## OFFICER REPORT

**Application Number:** 23/02183/CLD

**Site Address:** 62 Windsor Avenue Radyr Cardiff  
CF15 8BY

**Proposal:** Single storey side extension and associated works

SHEET TITLE:
PROPOSED OVERALL GROUND FLOOR PLAN

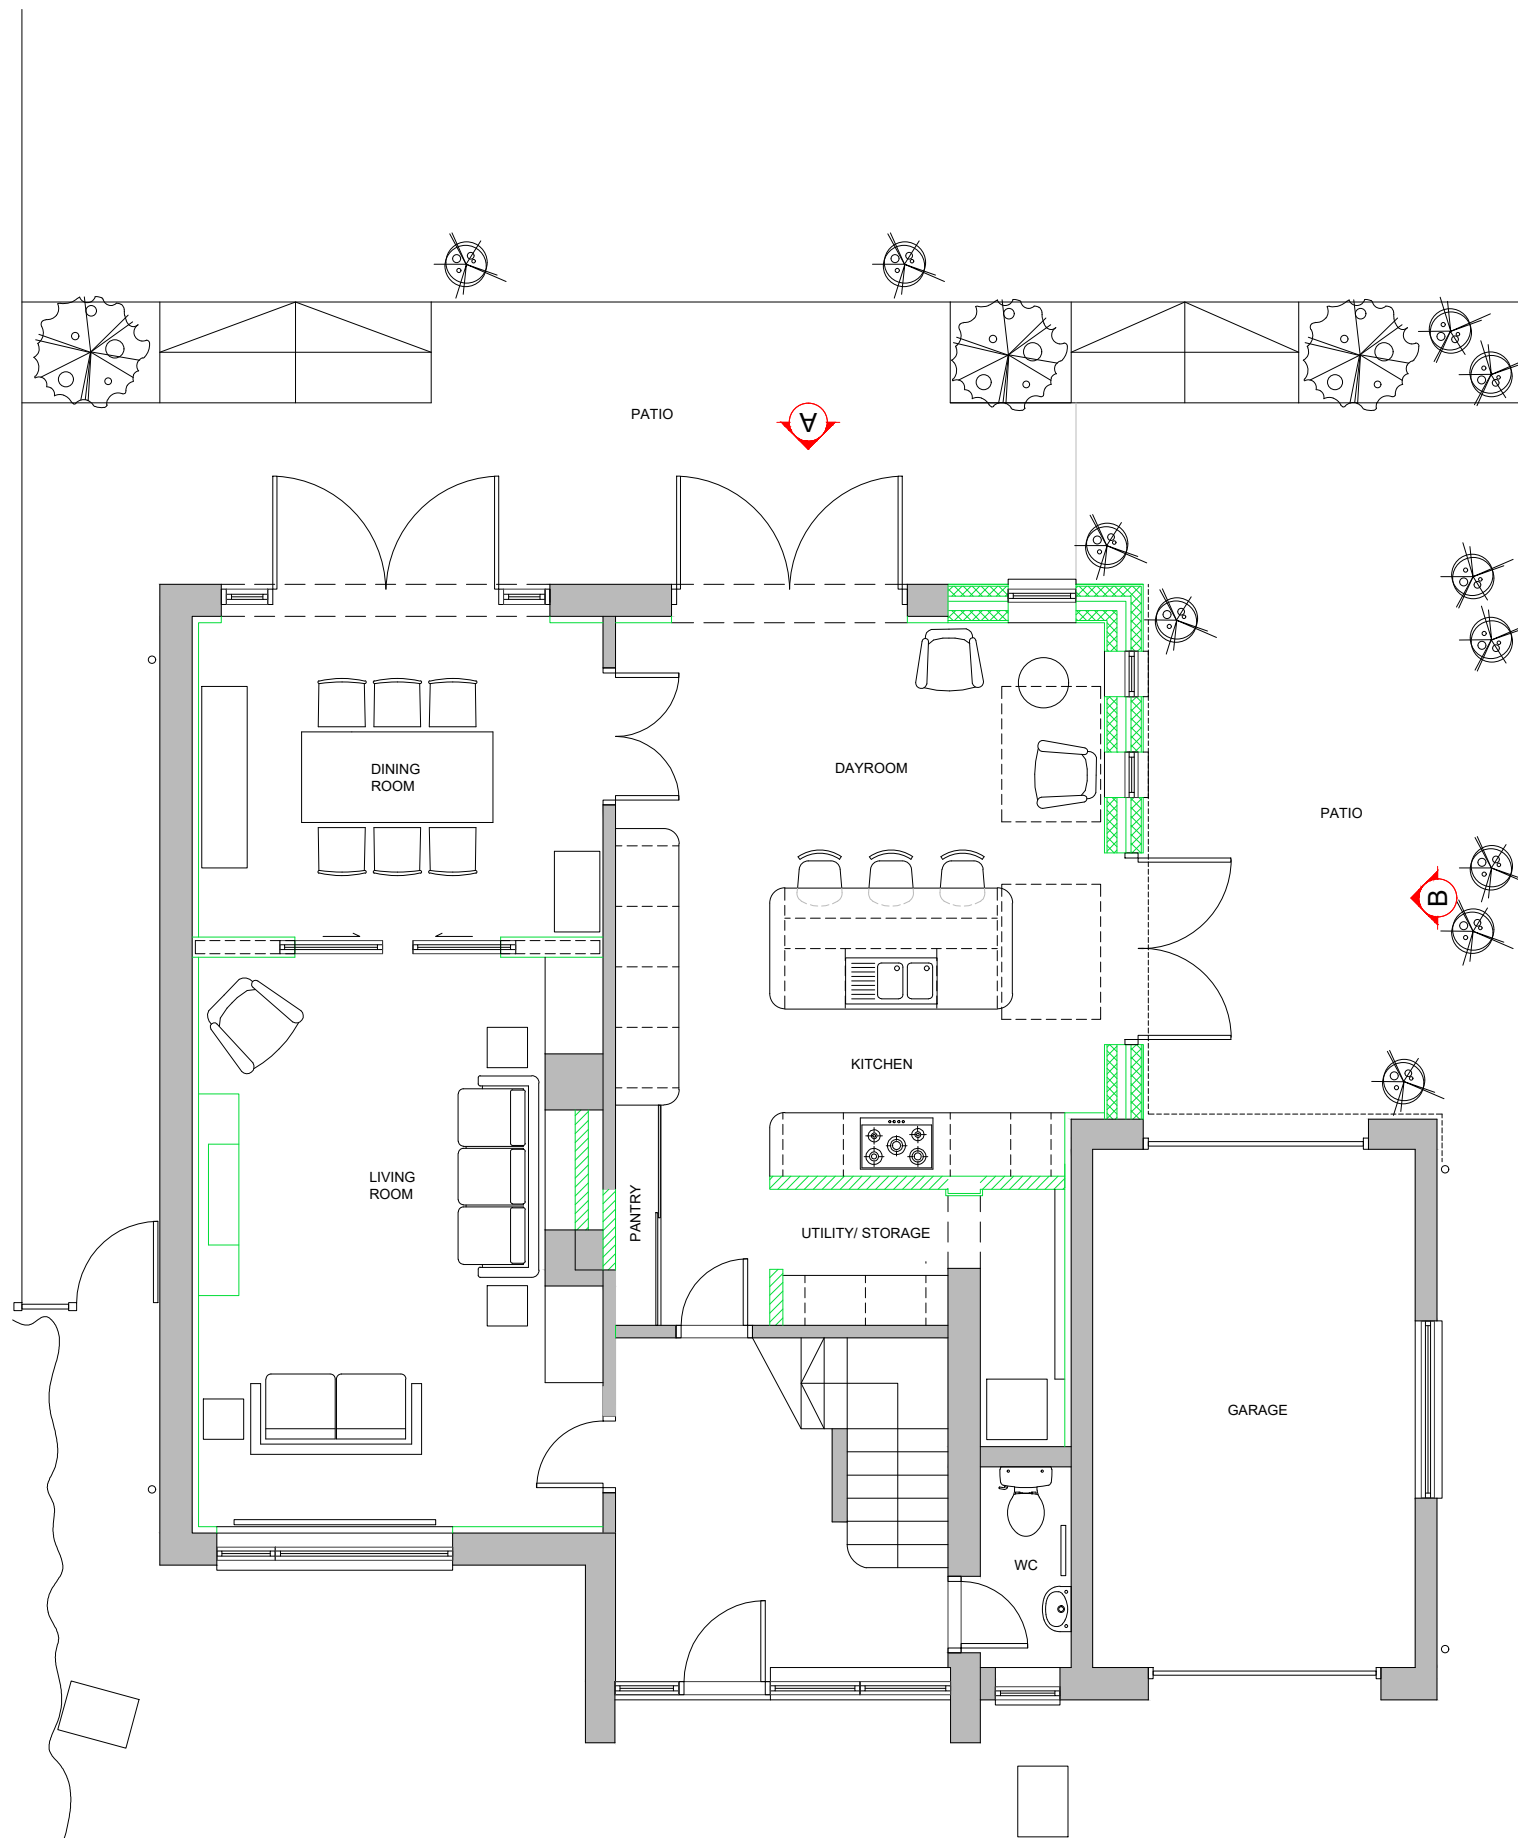
The proposal as detailed in the submitted plans would **NOT** constitute development permitted by Class A of Part 1 in Schedule 2 of the Town and Country Planning (General Permitted Development) Order 1995 (as amended for Wales), as the proposed extension would extend beyond the relevant parts of the rear wall of the original dwellinghouse by more than 4 metres contrary to paragraph A.1(i) of Class A.

**The extension would extend beyond the relevant parts of the rear wall of the original dwellinghouse by more than 4 metres.**
